KITTITAS COUNTY

MEMORANDUM

TO: All Staff
FROM: Public Works Plan Review Team
DATE: December 22, 2023
SUBJECT: BL-23-00028 Lent-Tumble Creek

BOUNDARY LINE ADJUSTMENT

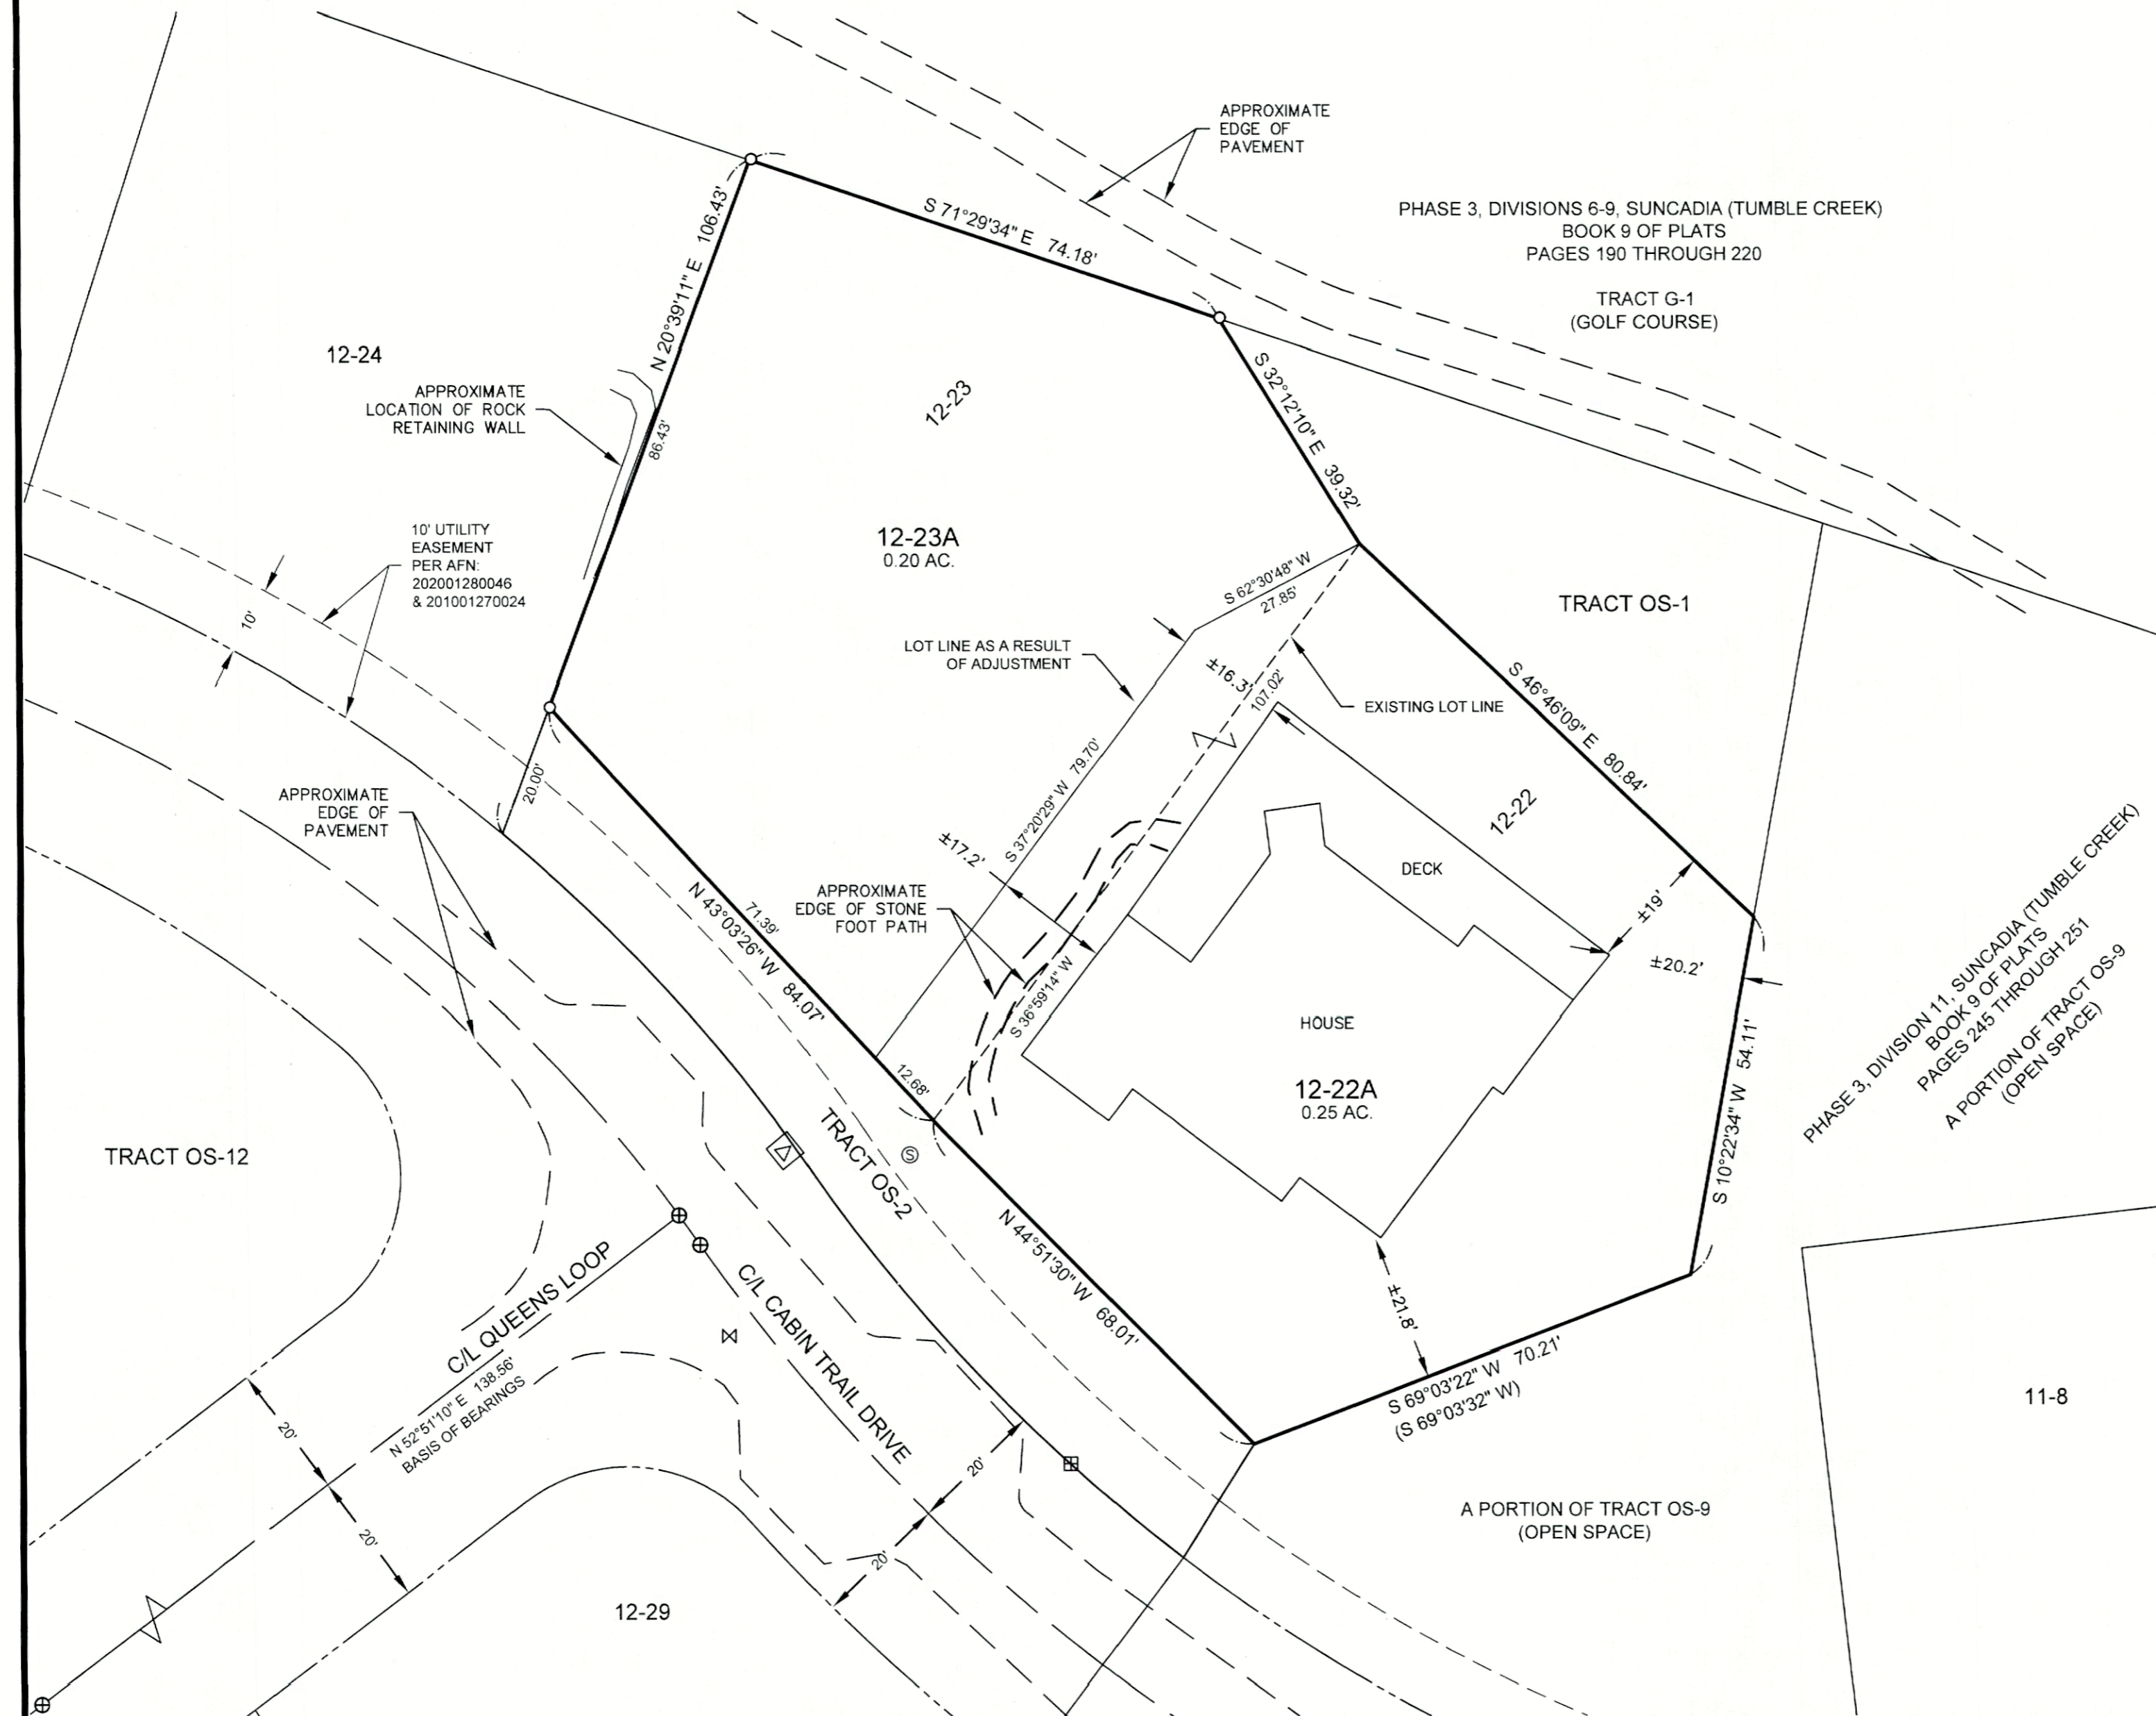
ACCESS	No comments. (JS)
ENGINEERING	<ol style="list-style-type: none"> 1. Except as exempted in Section KCC 14.05.060, no grading or filling upon a site involving more than one hundred (100) cubic yards shall be performed without a grading permit from the County Engineer or Public Works designee (KCC 14.05.050). An application for grading in excess of five hundred (500) cubic yards shall be accompanied by an engineered grading plan (KCC 14.05.080). (KH)
SURVEY	<p>The submittal meets all the survey requirements for the BLA application. The following comments are in regards to the final BLA:</p> <ol style="list-style-type: none"> 2. Please include reference to Plat 12-121 for the lots south and west of the subject parcels. 3. At a minimum, the corners of the new division line shall be shown on the face of the survey and set in the field. 4. If the found road monuments were utilized as survey control, suitable ties linking the subject property to these monuments shall be shown on the face of the survey.
